Our Ref: 22/50504/PREAPP
Your Ref: HSPPGRMP

SOUTH CAMBRIDGESHIRE DISTRICT COUNCIL
Application for Pre-application advice

Site address: Benevenagh 26 Home Close Histon Cambridgeshire

Roof extension.

Drawing Title:
ELEVATIONS
proposed

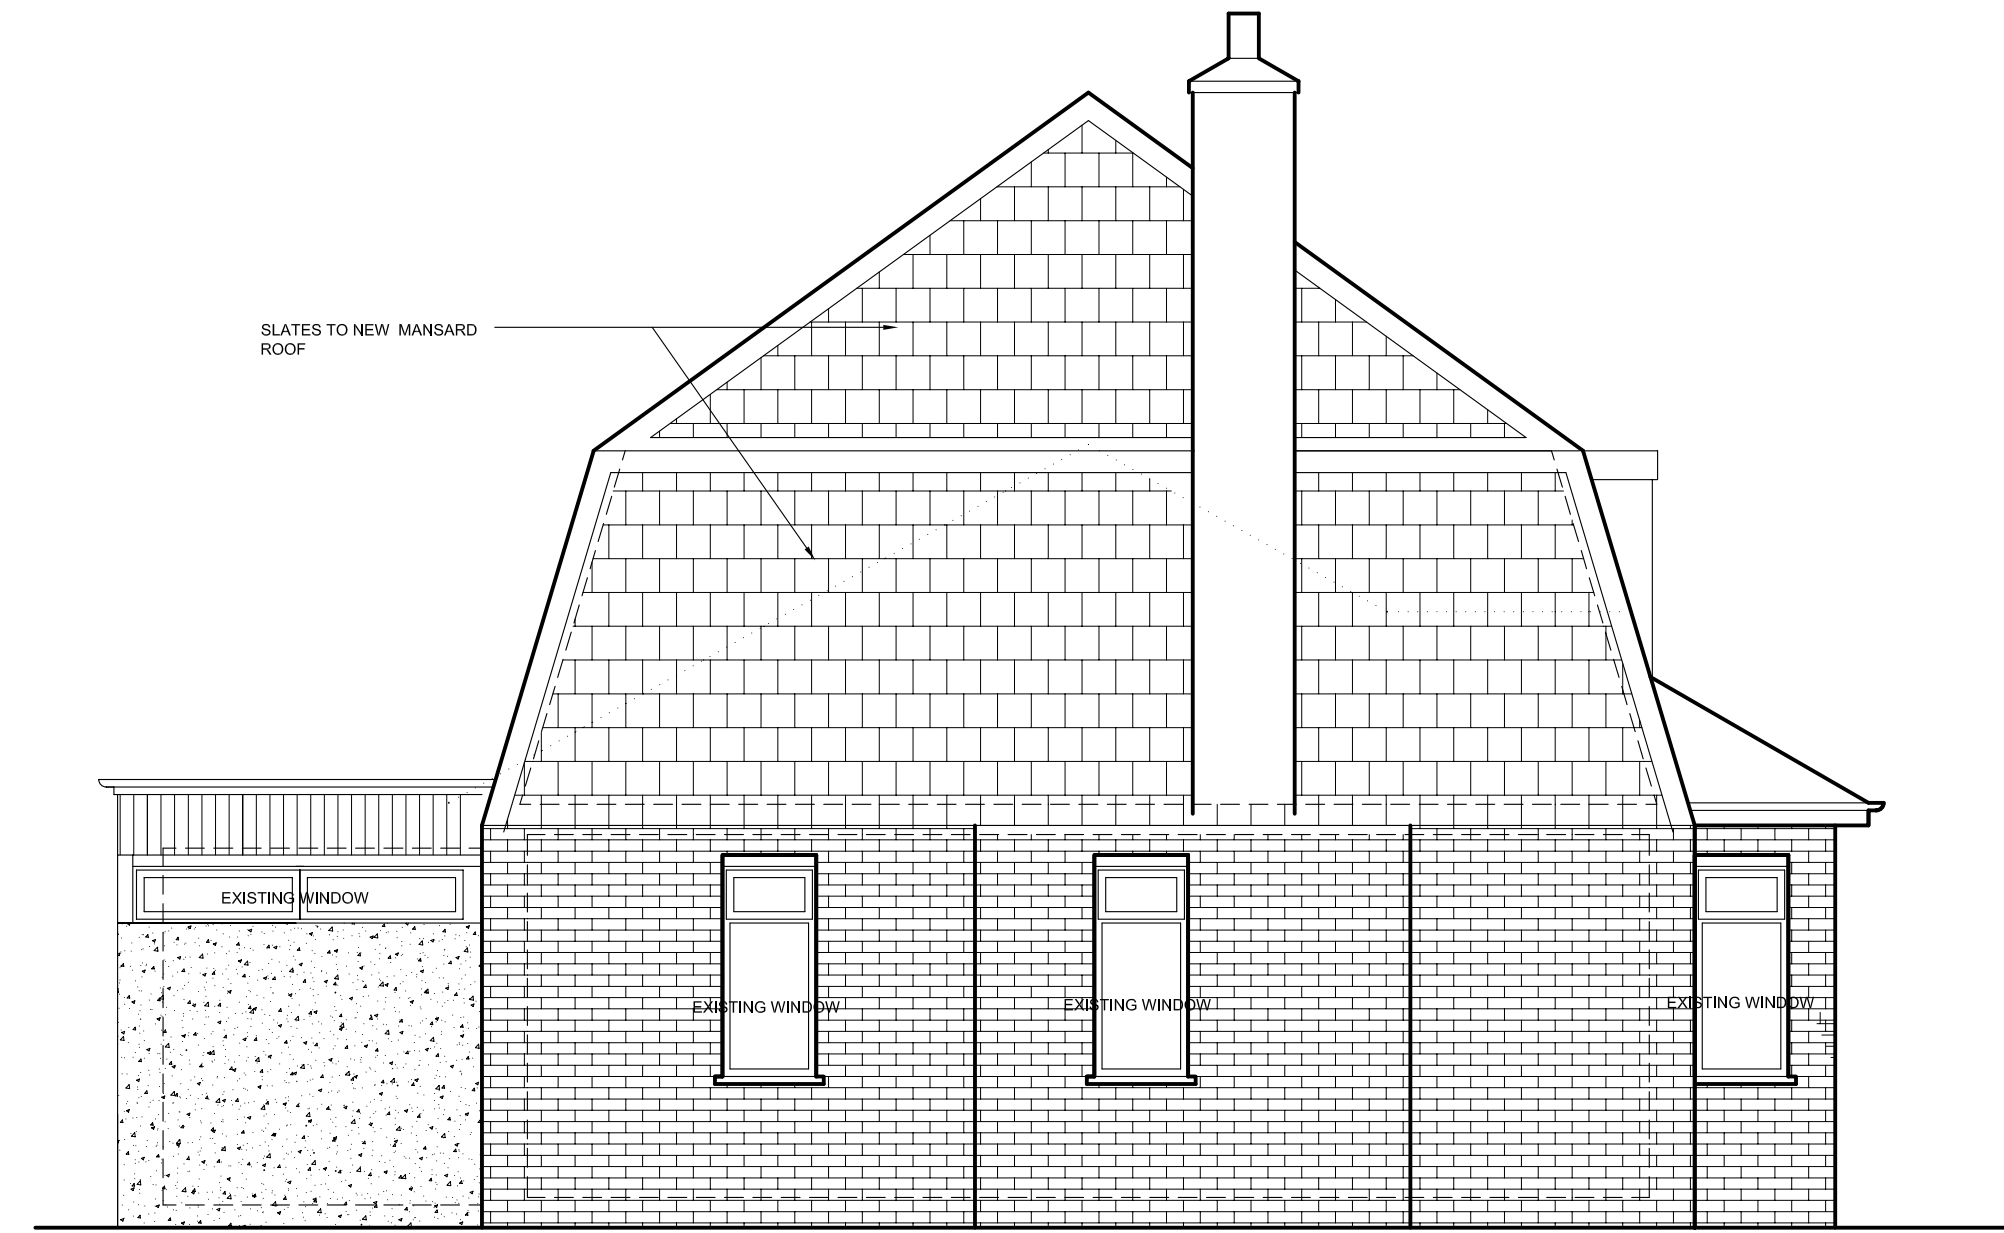
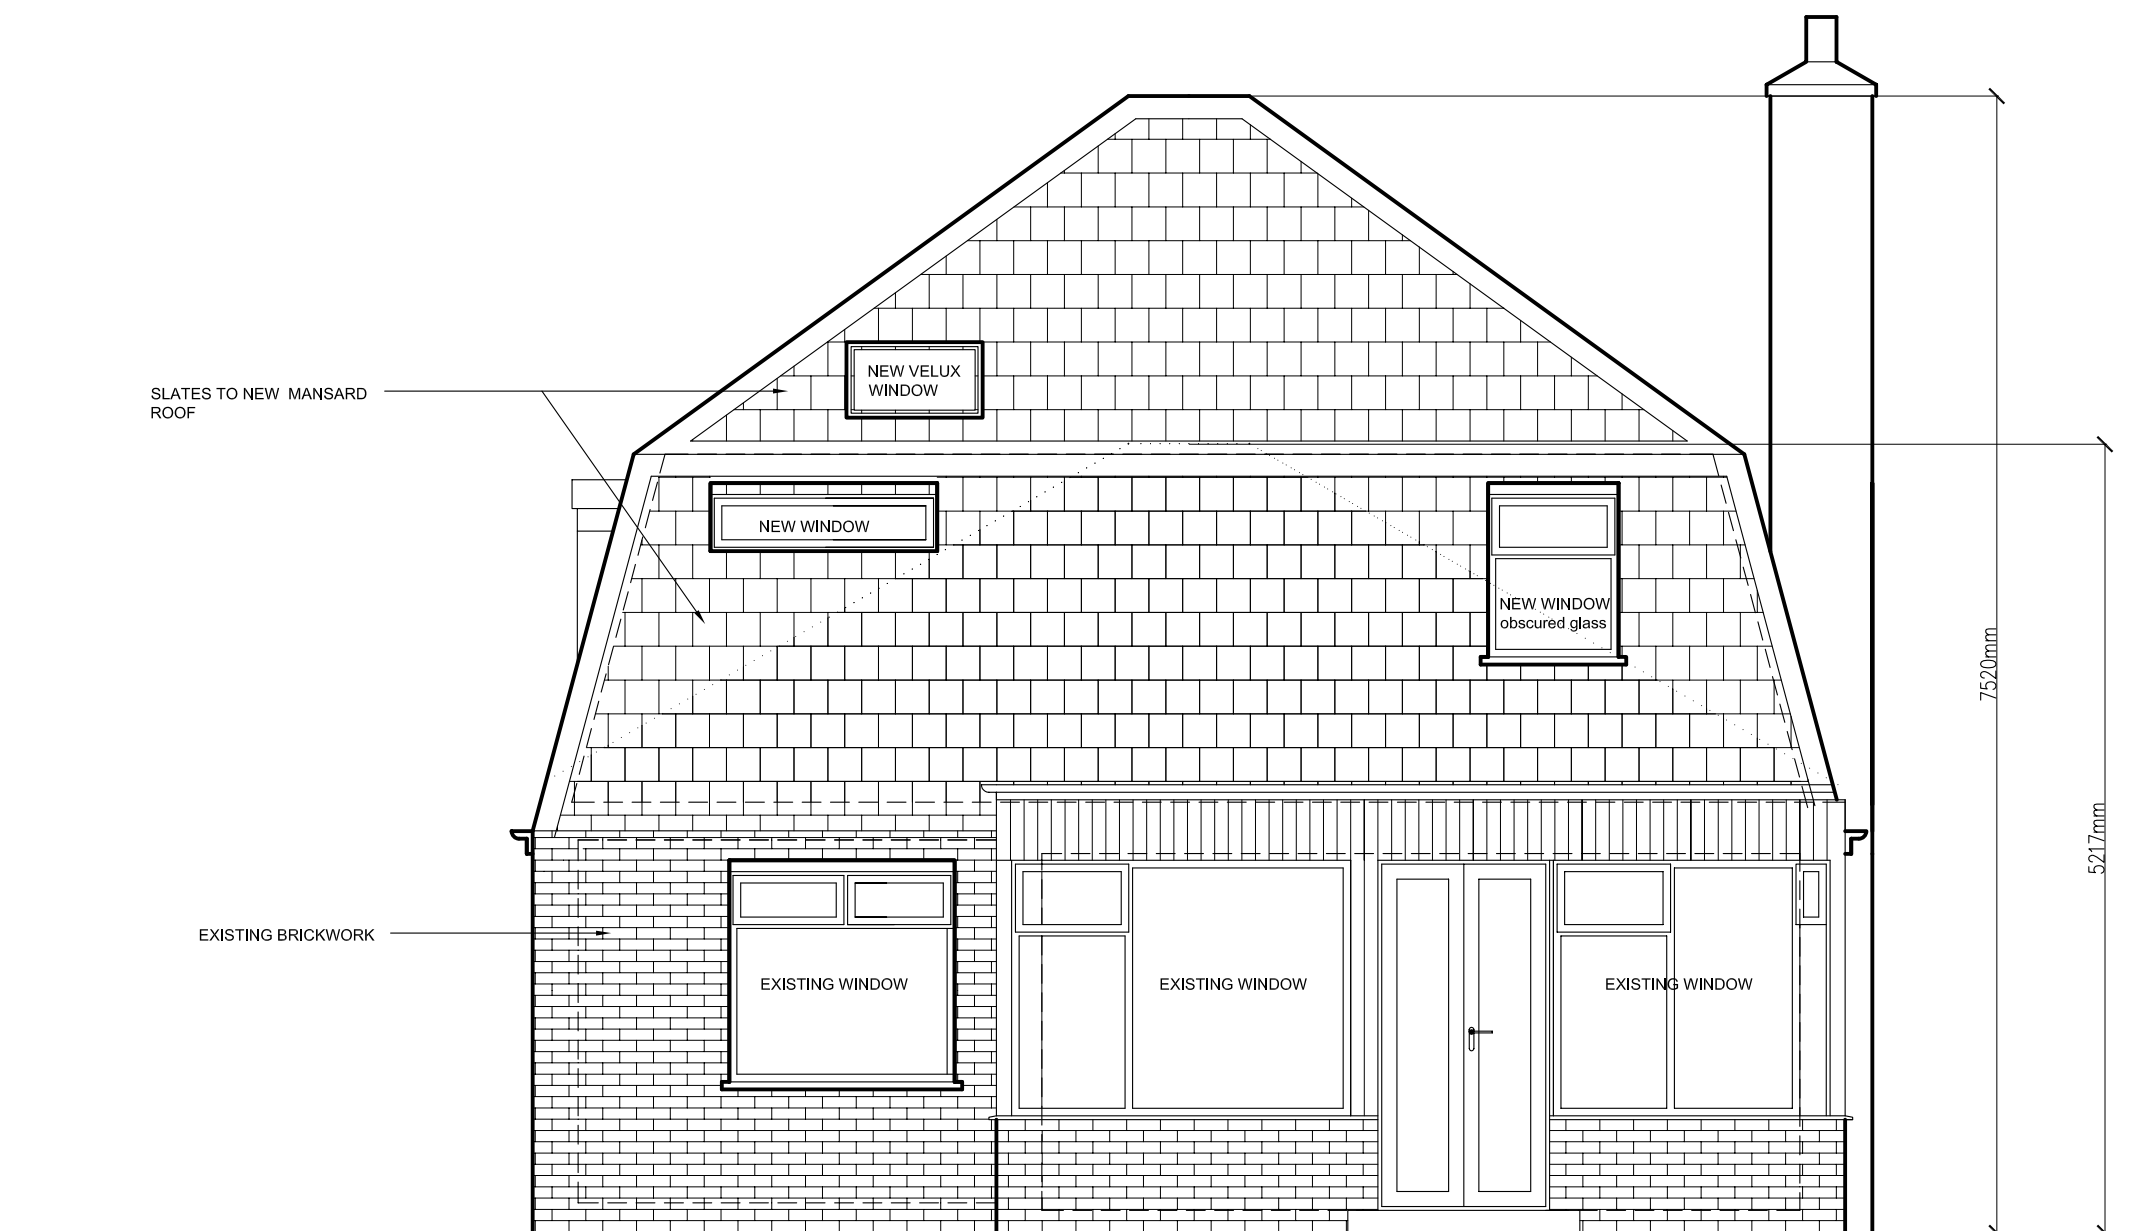
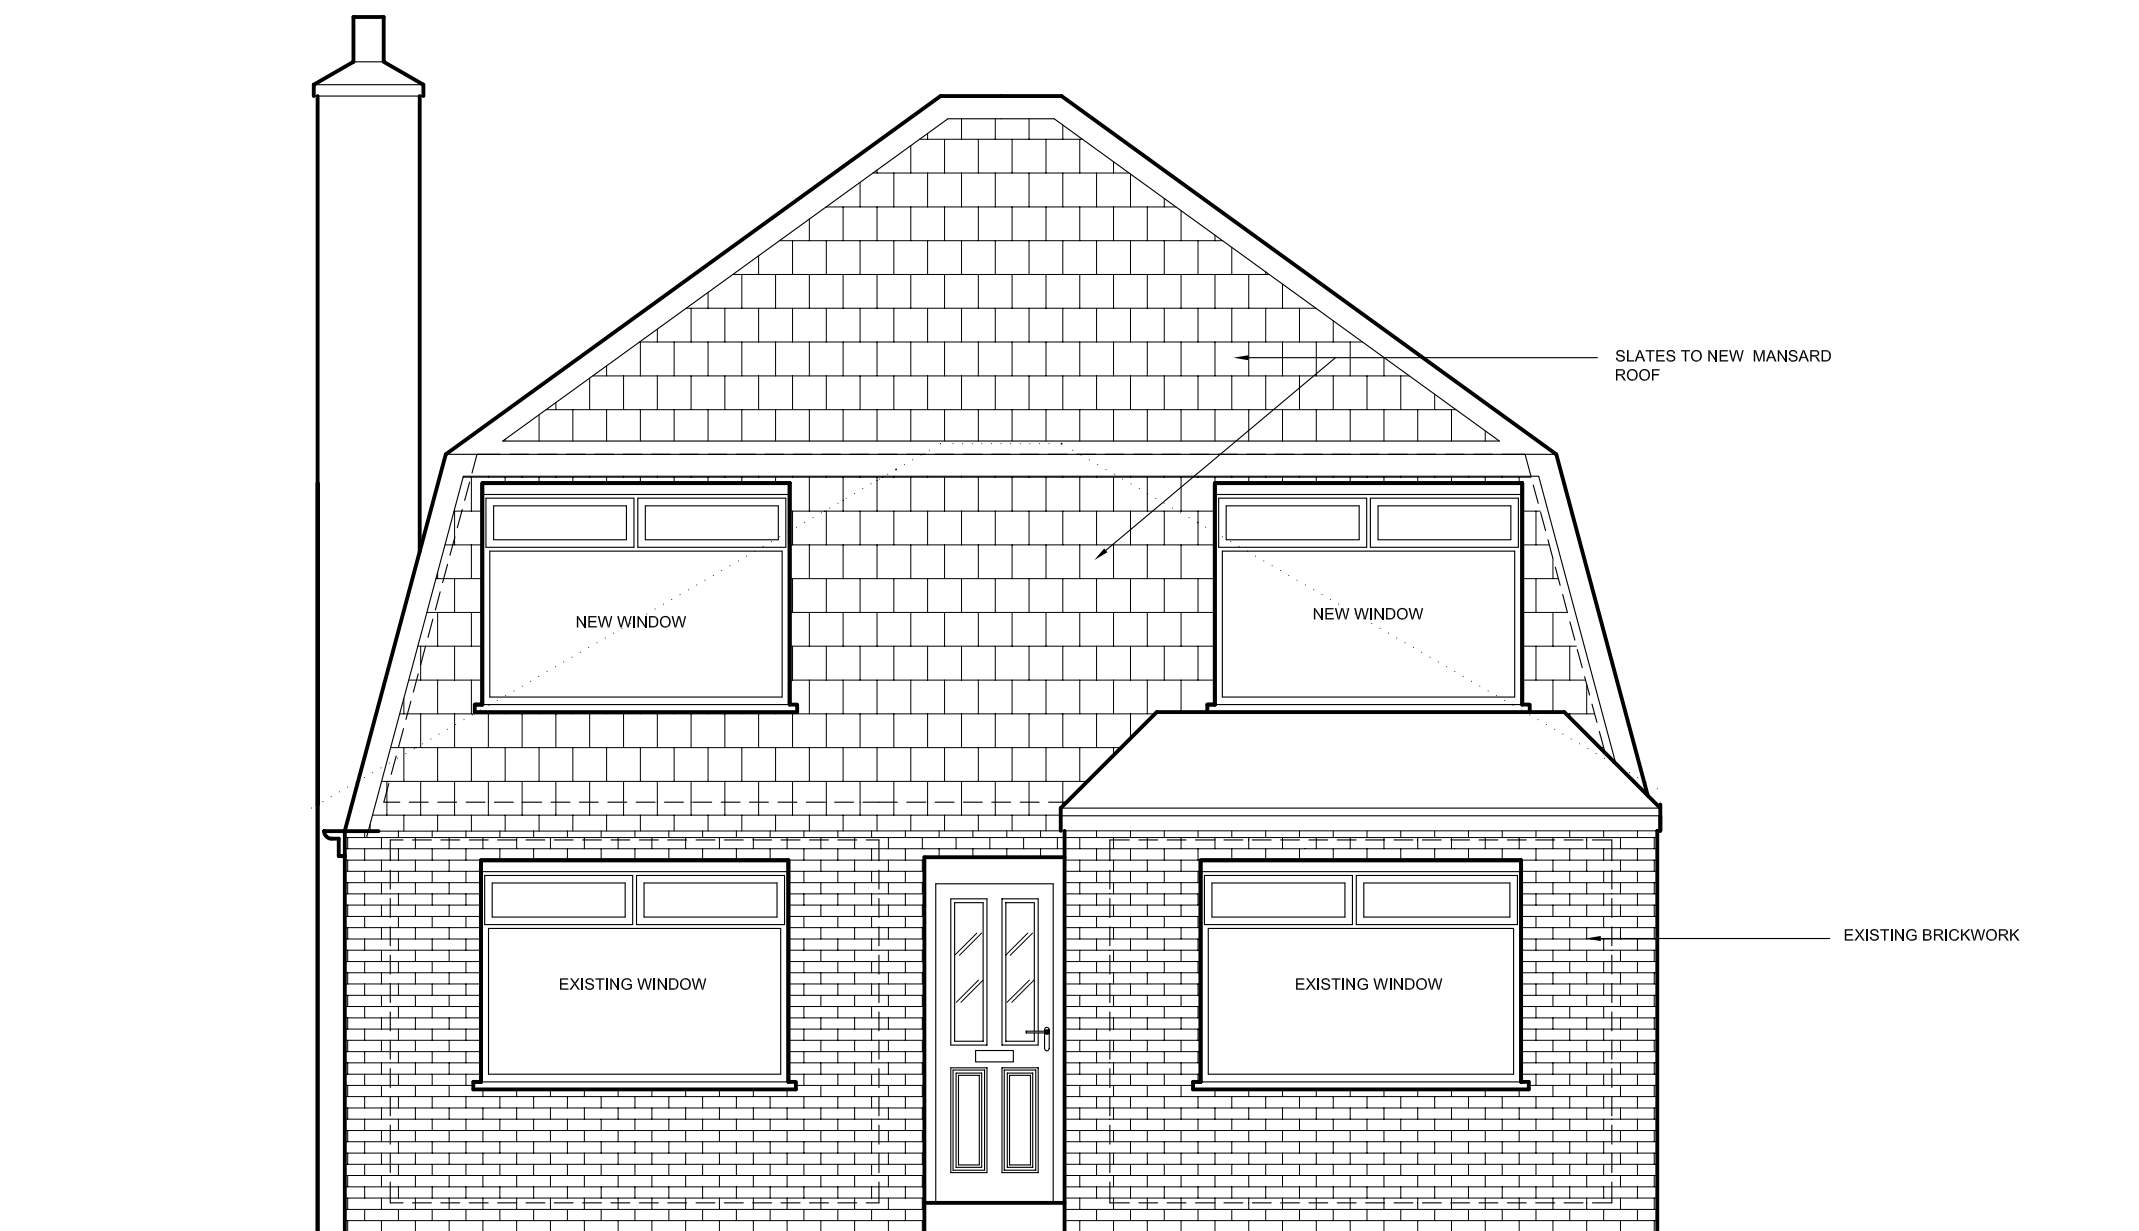
Issue	Summary response	RAG
Principle	<p>Acceptable to add a first floor to the existing bungalow to create a two-storey dwelling, given the surrounding two storey scale to the south and noting other examples of this development along Home Close. The application site falls within a grouping of bungalows, yet officers are satisfied that the proposed extension would not adversely impact upon this grouping.</p>	G
Context, design and external spaces	<p>Home Close is relatively mixed in architectural character given the mix of architectural styles, yet a common theme is that all dwellings are sited back from the street.</p> <p>The proposed extension would create a mansard roof form which is present in the surrounding context (no. 28, 30, 39 & 40). Yet the application site falls within a grouping of bungalows all with hipped roofs and this would interrupt this grouping. That being said, officers, while preferring a less complex roof form, do not consider that it would be out of character with Home Close given the presence of others in the street and the mixture of styles.</p> <p>The mansard roof form was adopted to decrease the massing at either boundary and roof level. Perhaps this can be achieved with a more contemporary design.</p>	G

Residential amenity	<p>No. 28 Home Close is a two-storey dwelling located to the south and has two windows on the side elevation. The window closest to the boundary is the only window serving the living room and the window sited further away is the only window serving the galley kitchen.</p> <p>Upon request, the agent has provided plans with the BRE 45 and 25 degree line on the proposed plans. The proposal would interrupt the 25 degree line from the kitchen window of no. 28. The existing hipped roof dwelling does not intercept this 25 degree plane from the midpoint of the window. This window may well be impacted by the proposed development, in terms of light. A daylight sunlight assessment would need to be submitted to demonstrate that adequate light levels would be maintained to the kitchen.</p> <p>In terms of outlook, officers are less concerned, given the existing situation.</p> <p>The sitting room has two windows which</p>	R FI

<p>serve it, one on the rear return and one (which is obscure glazed) on the side elevation sited forward of no. 26. The proposal would not impact upon the 25-degree plane as it is set forward of no. 26. Taking a 45-degree line horizontally, the existing and proposed breach this rule. Taking this into account, alongside the orientation and that the side window is obscure glazed, officers may have less concerns regarding light to this window.</p> <p>In terms of the rear window serving this living room, the proposed development would not interrupt the vertical 45-degree plane here. As such, officers would likely conclude that this window / rooms light level would not be significantly impacted by the development. Outlook from this habitable room would be retained to the rear</p> <p>In terms of overlooking, the rear elevation contains an obscure glazed window and a high-level window to prevent overlooking / loss of privacy to the bungalow to the north.</p>
